re: **Grading Plan Review**  
**Proposed Community Centre**  
**351 Sandhill Road - Ottawa**

file: PG4228-MEMO.02

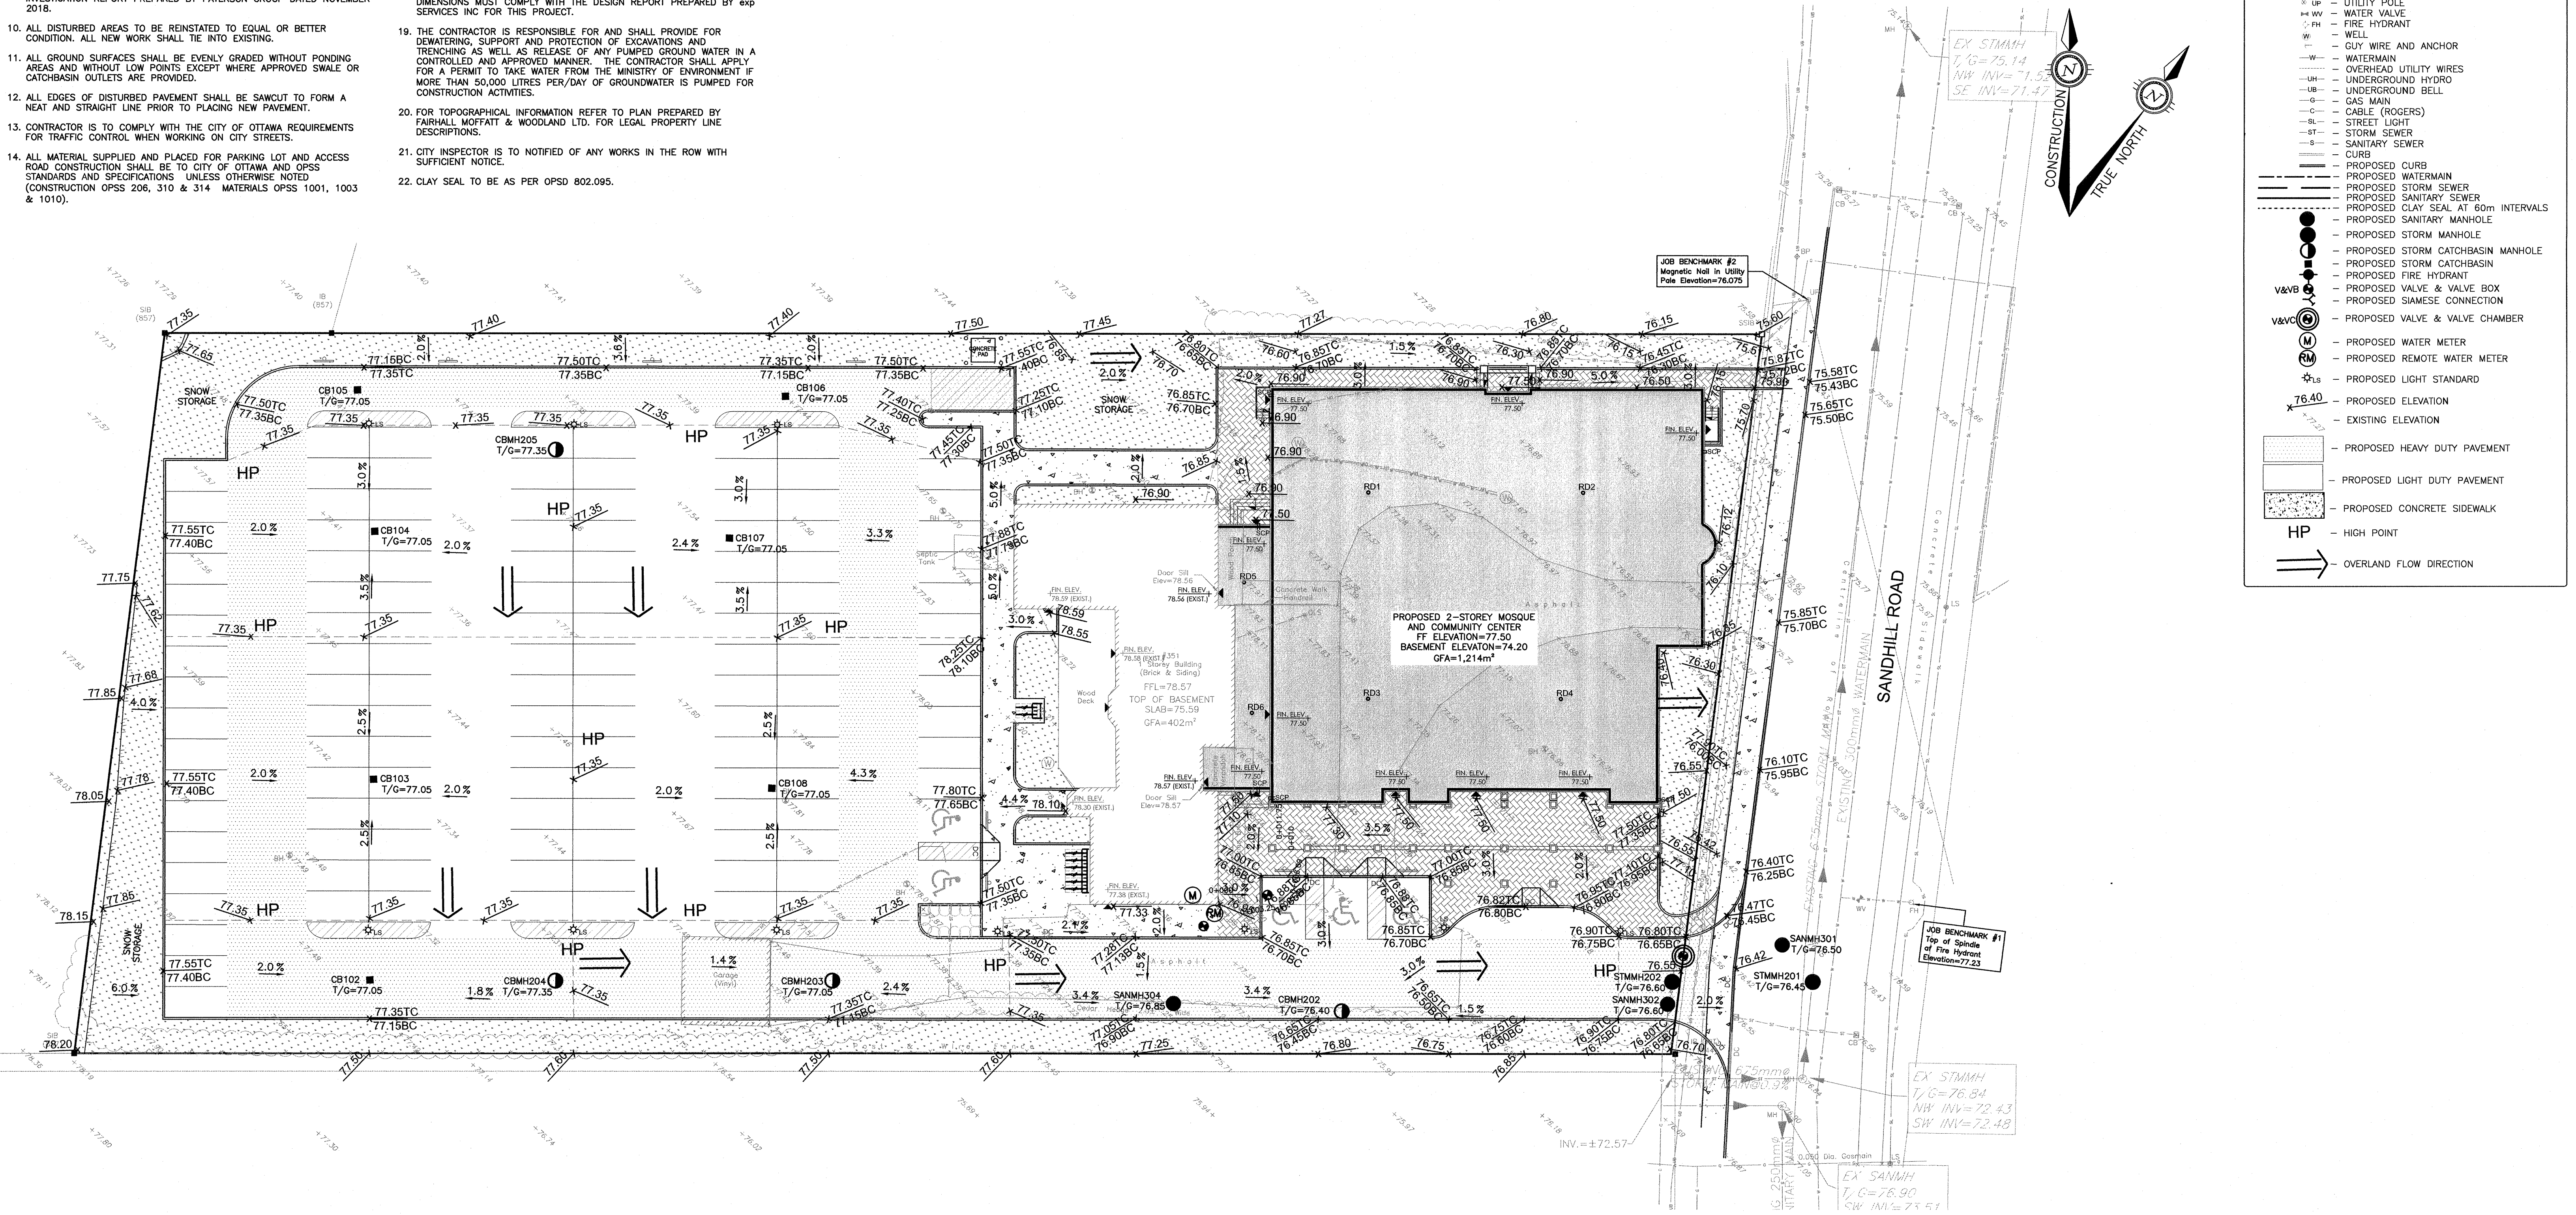
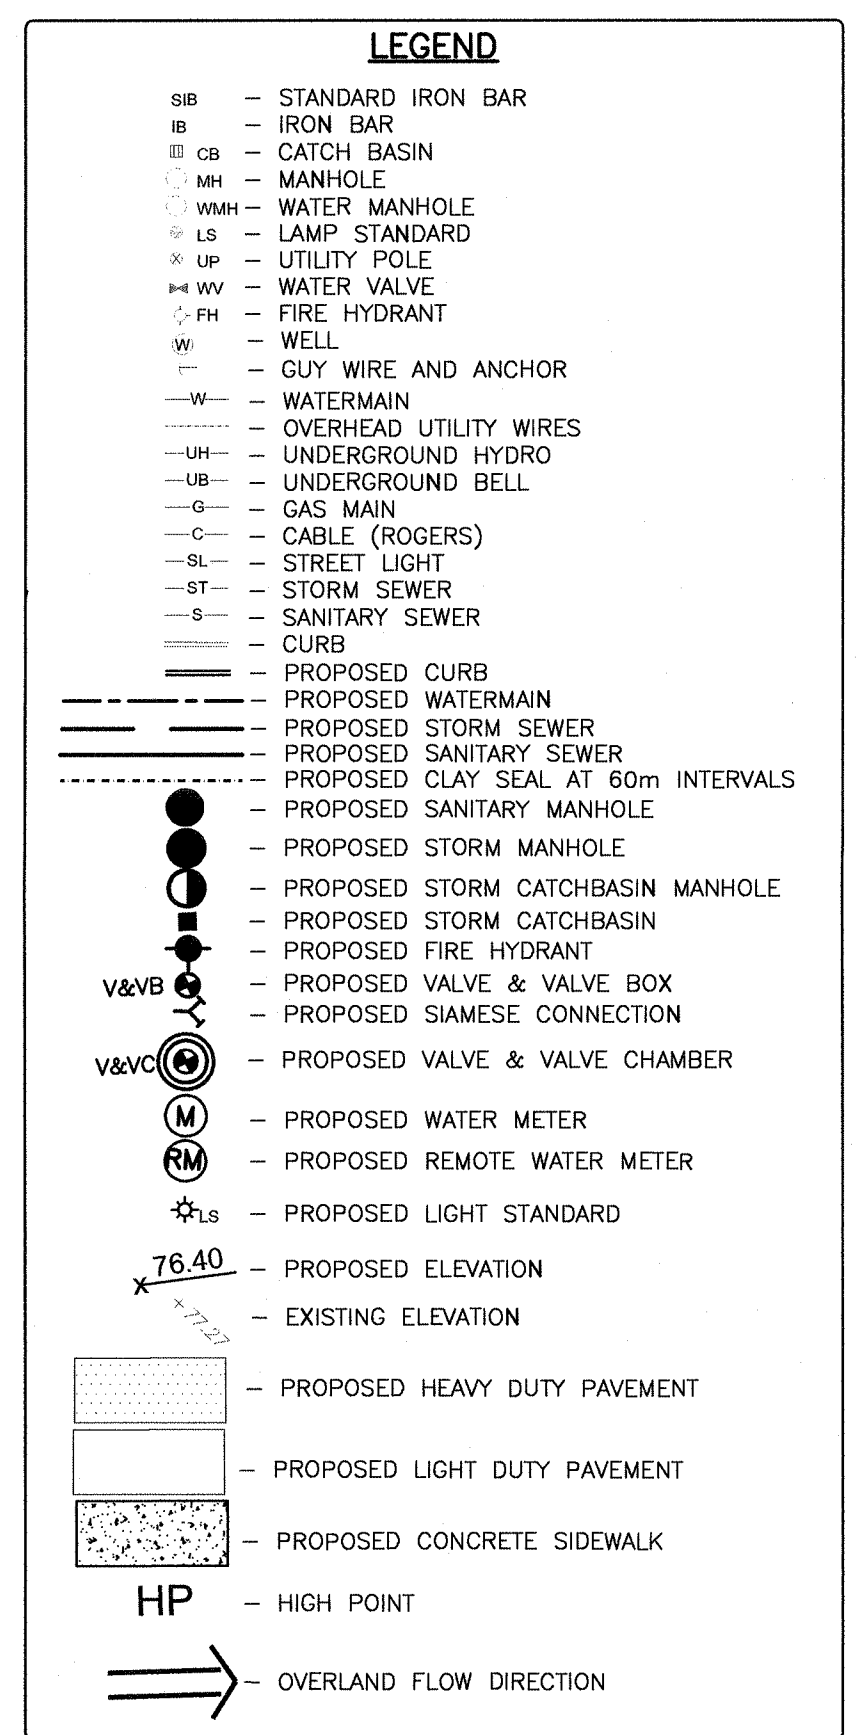
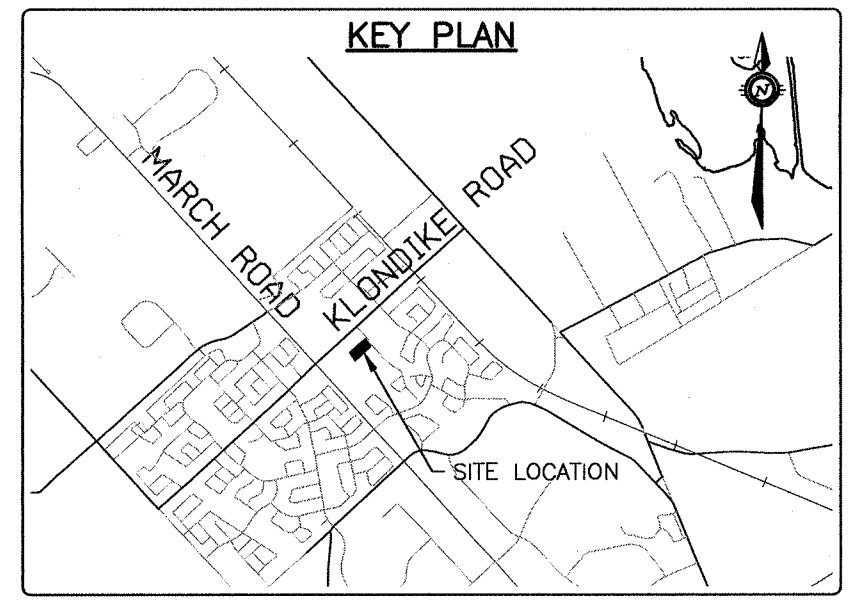
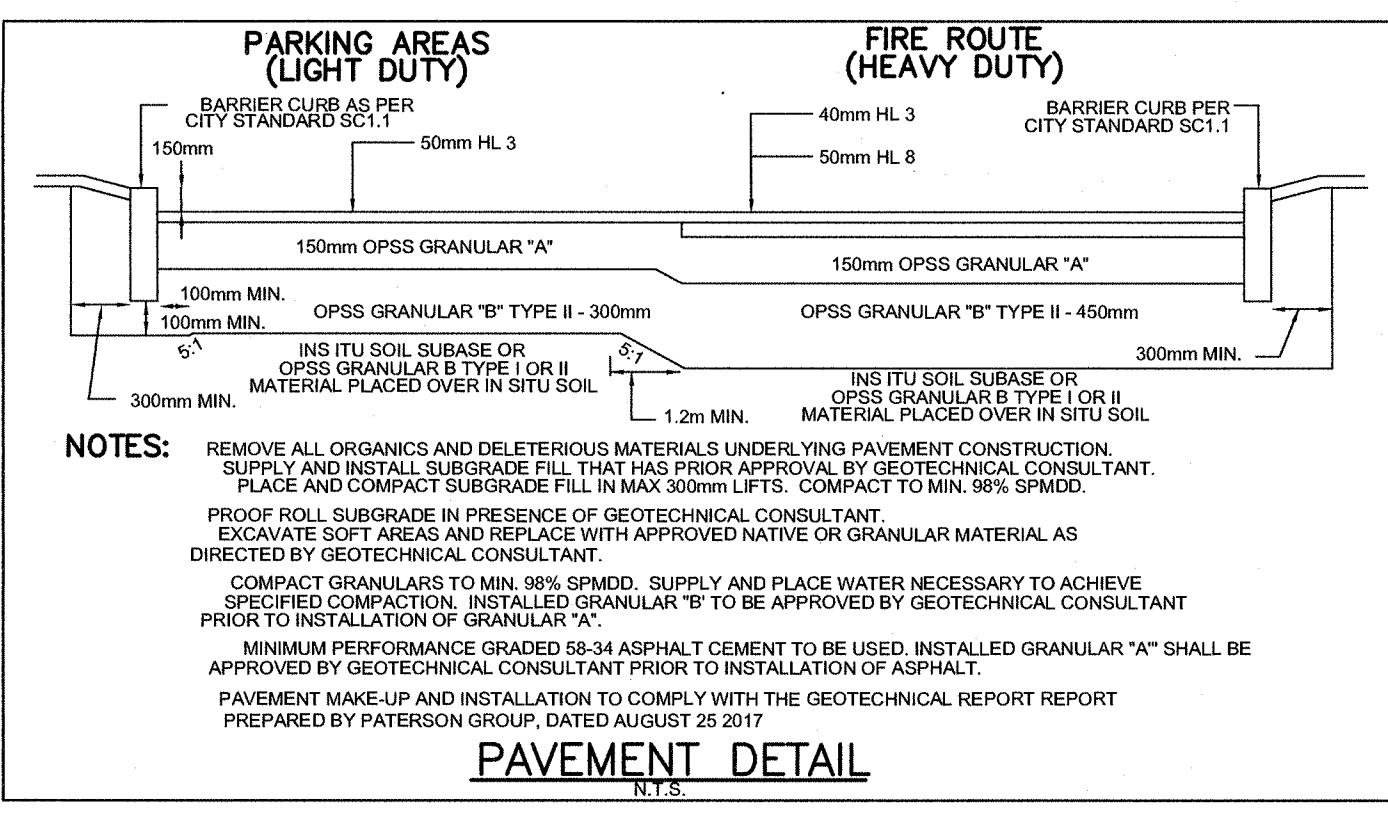
Based on the grading plan provided, the proposed grades are less than the permissible grade raise restriction of 2 m and are acceptable from a geotechnical perspective. Therefore, no lightweight fill is required for the proposed buildings from a geotechnical perspective.
